16 October, 2018

Our ref: 17/96

**RE: SHOALHAVEN STARCHES EXPANSION PROJECT (MP06_0228 MOD 16)
PROPOSED NEW SPECIALTY PRODUCT PROCESSING FACILITY, NEW GLUTEN
DRYER AND OTHER ASSOCIATED WORKS
RESPONSE TO SUBMISSIONS**

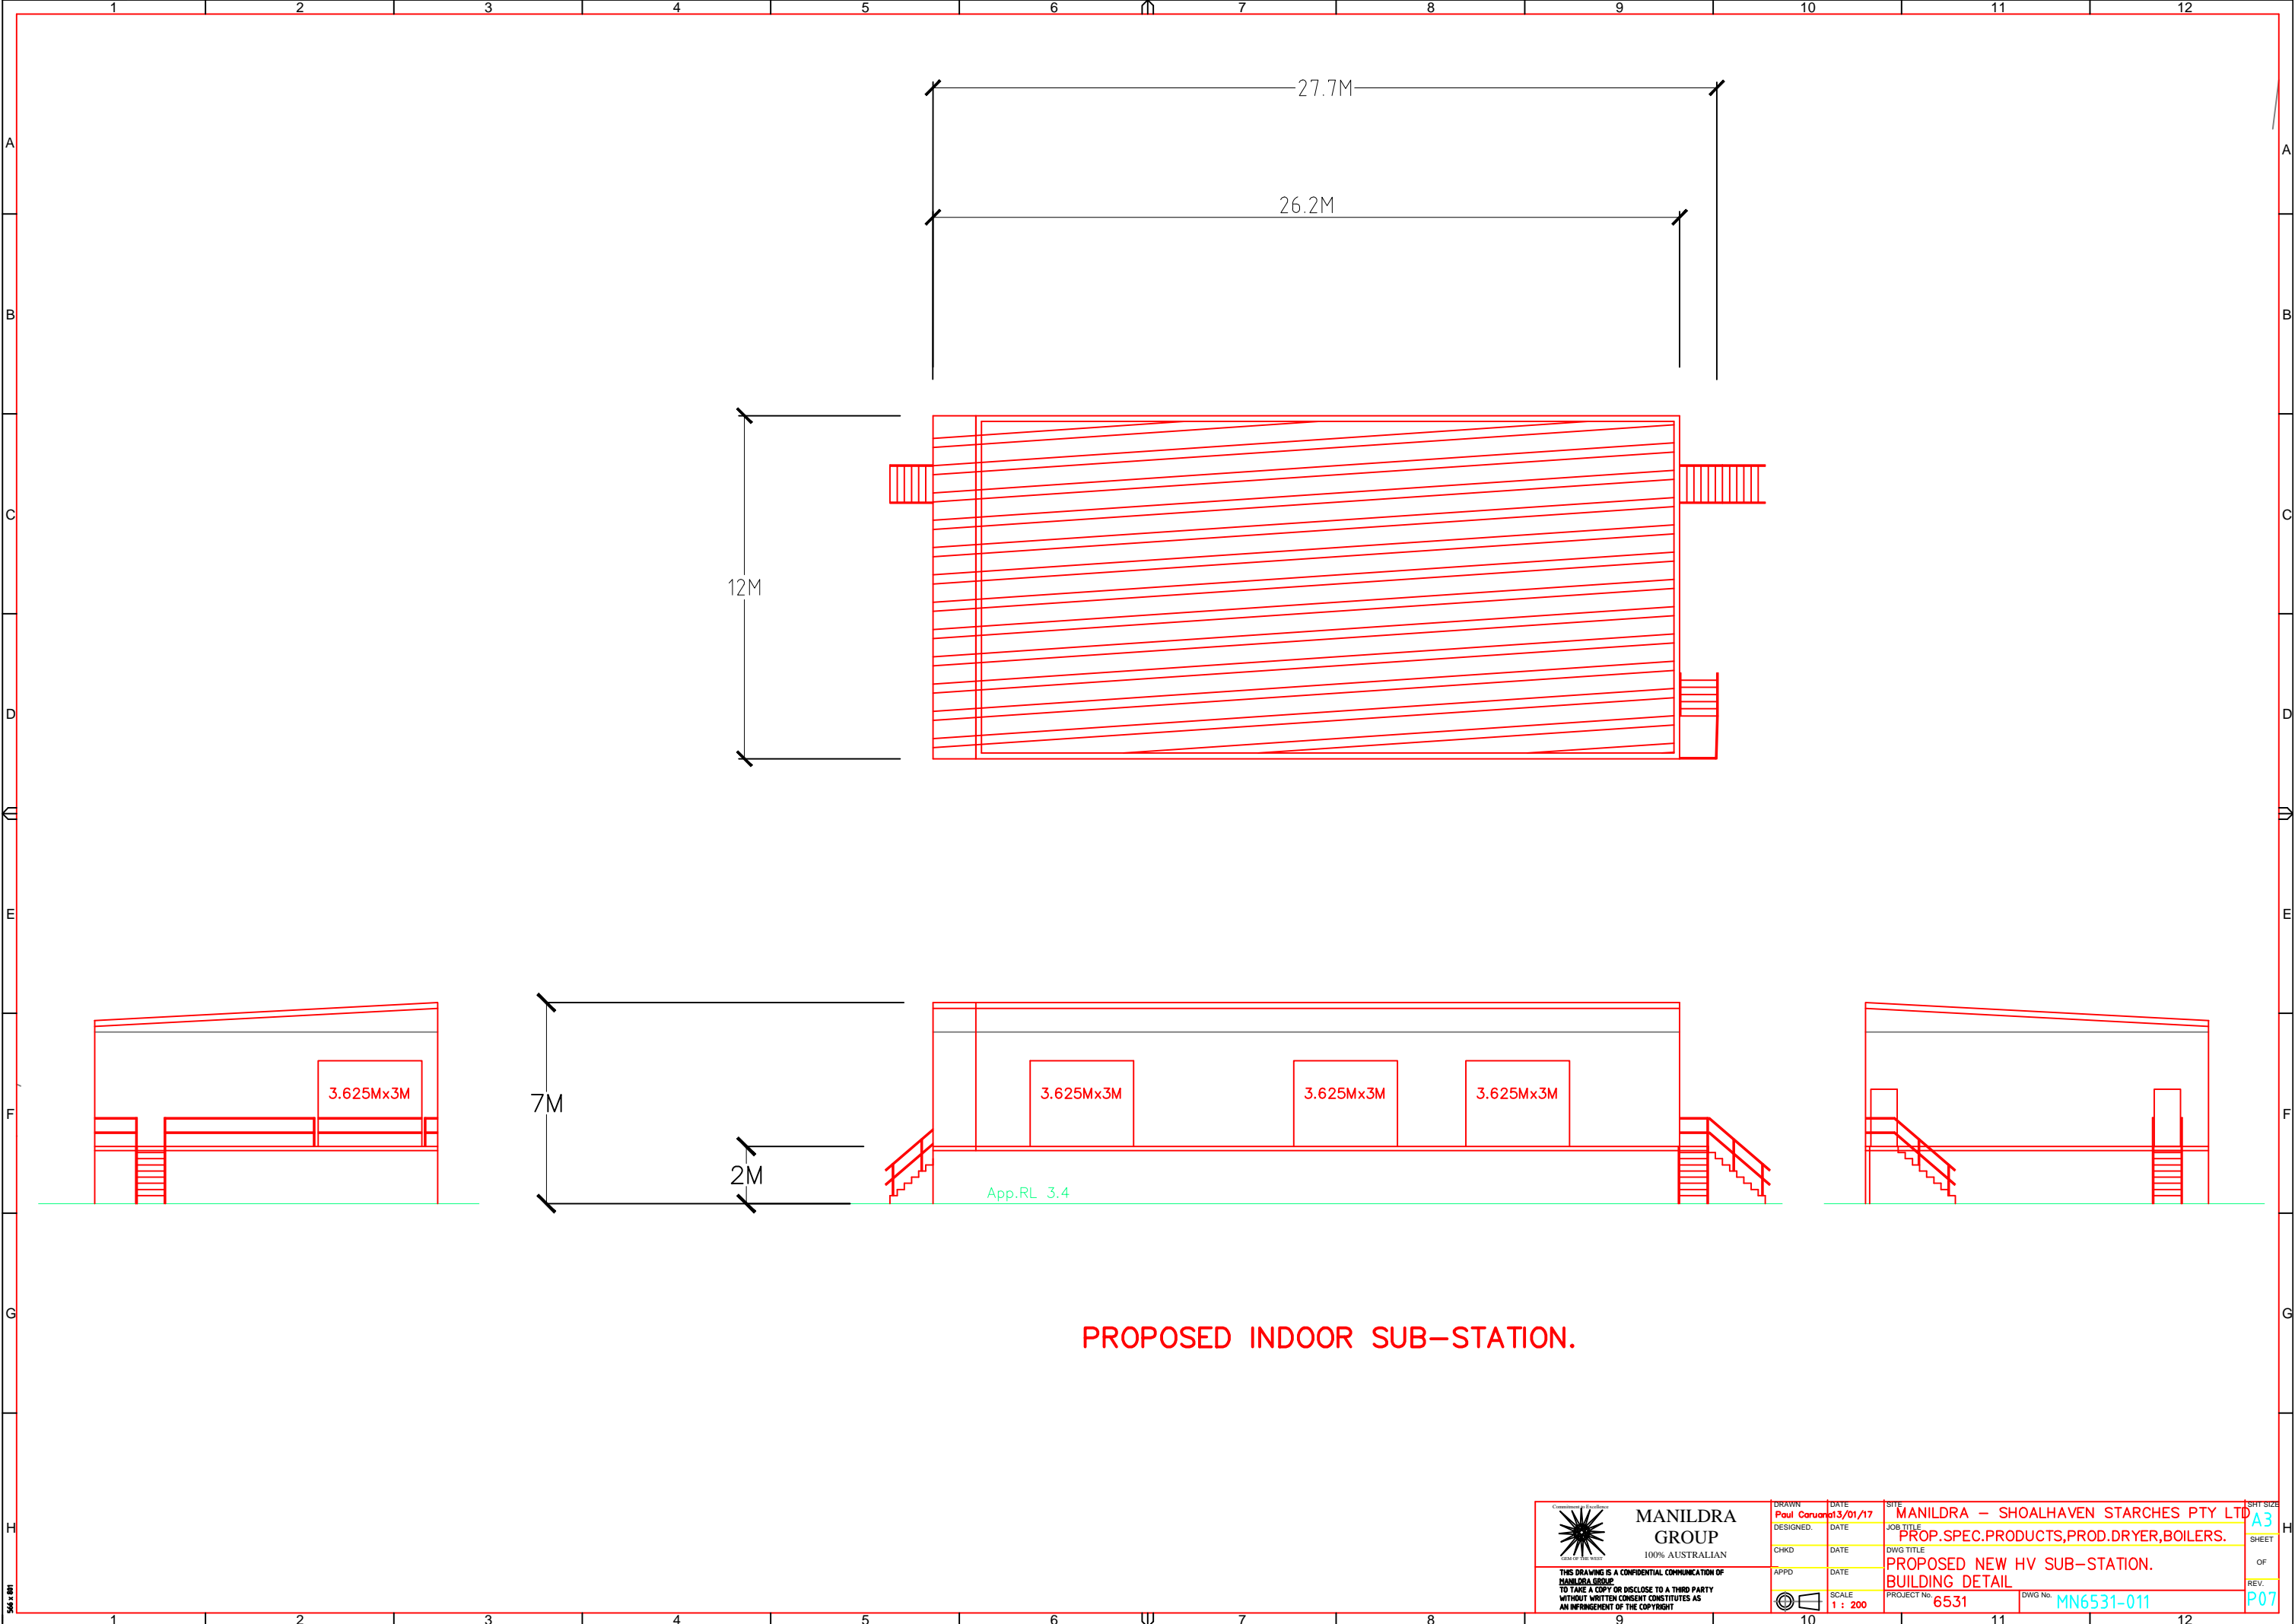
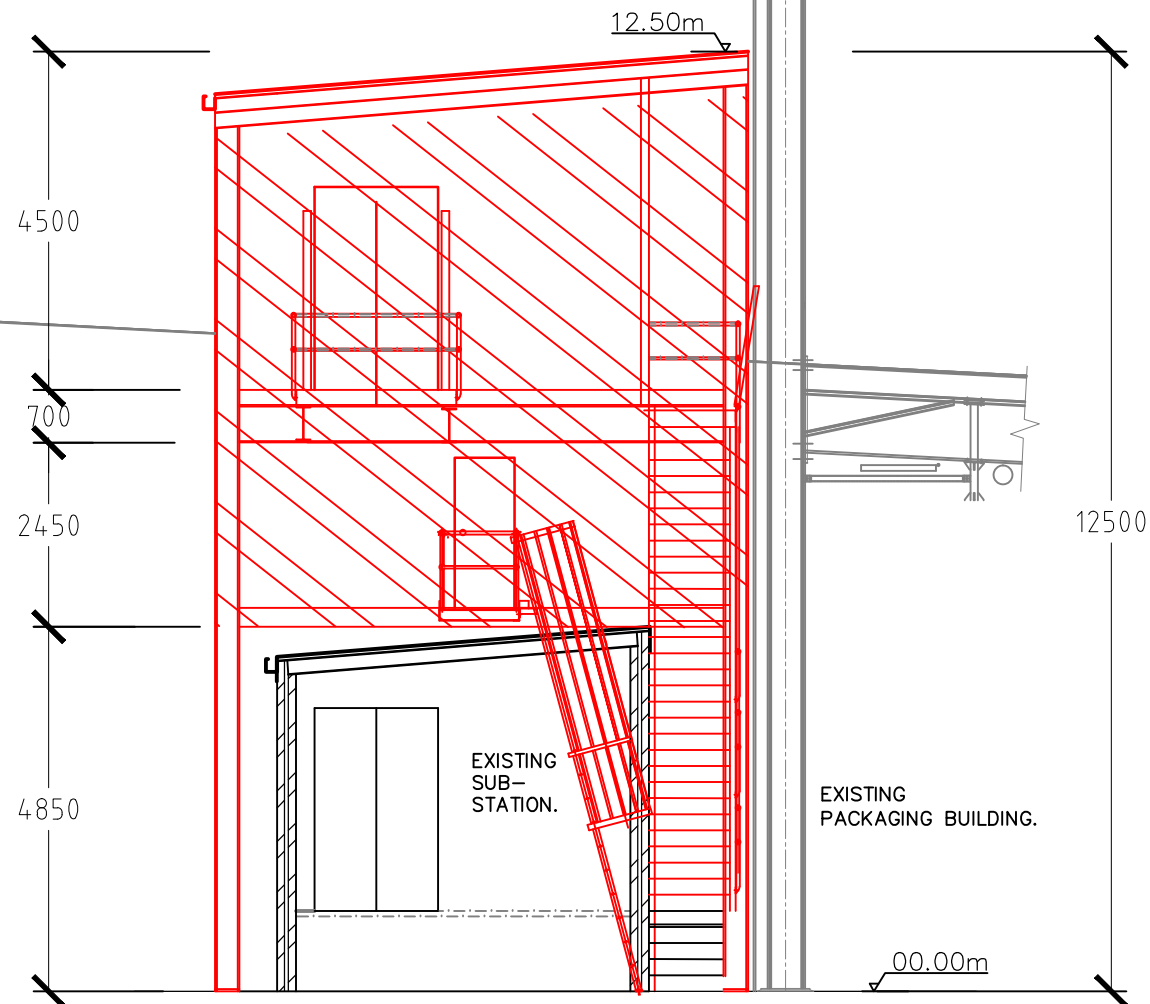
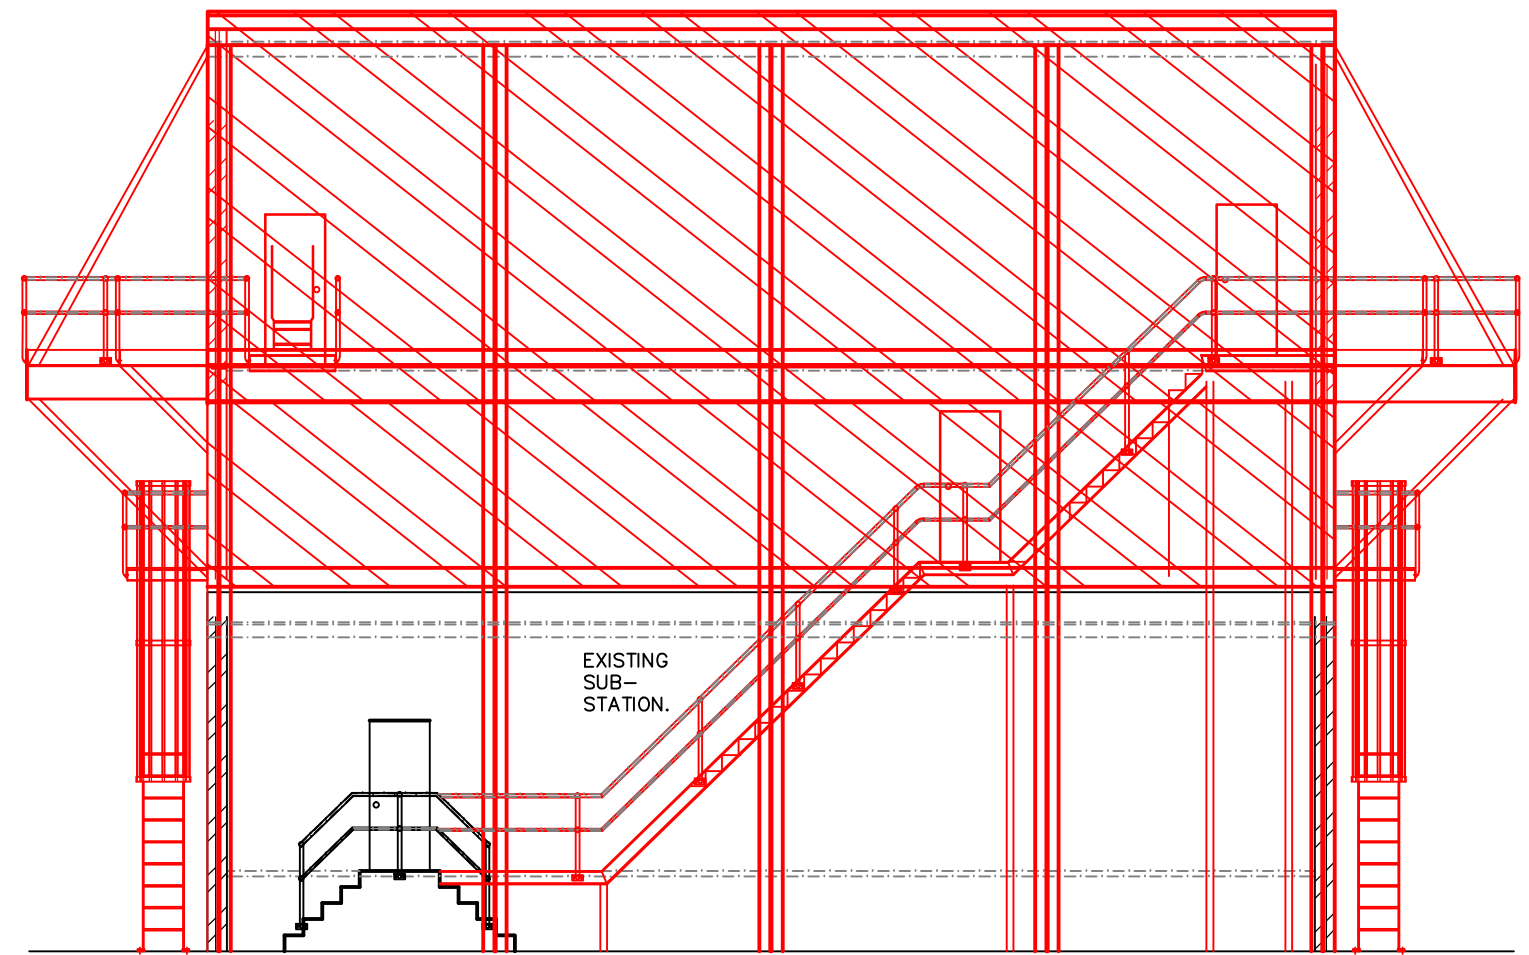
1. *This application proposes to relocate 26 existing off-street car parking spaces from the BOC site to the east to accommodate the new indoor HV substation. The drawings accompanying the application do not show which spaces will be relocated and which will remain. The drawings do not provide any indication of car park space dimensions or the width of circulating aisles. Unless spaces are marked, maximum capacity is not achieved as cars are parked at different angles and wider apart. The Department has previously adopted Council's recommendation that the proponent delineate parking spaces using plastic disc markers or paint to achieve maximum parking capacity.*

- a. *Scale drawing(s) of the BOC carpark will need to be provided to demonstrate which of the existing car parking spaces will be relocated and which spaces will remain.*

- b. *The car parking at the BOC site is to be designed to comply with the parking space and aisle dimensions outlined in AS2890.1 (Parking facilities – Part 1: Off-street car parking) and AS2890.2 (Parking facilities – Part 2: Off street commercial vehicle facilities).*

Attached to this submission are plans drawn to scale of the proposed relocated parking spaces on the BOC site. The plans demonstrate the parking spaces will comply with AS2890.1 (Parking facilities – Part 1: Off-street car parking) and AS2890.2 (Parking facilities – Part 2: Off street commercial vehicle facilities).

The current proposal merely seeks to relocate parking spaces. It does not seek to alter the temporary nature of the spaces. Under these circumstances there is no need for these parking spaces to be bitumen sealed as preferred by Council. These parking spaces will be constructed to an all-weather aggregate finish consistent with the existing approved situation.
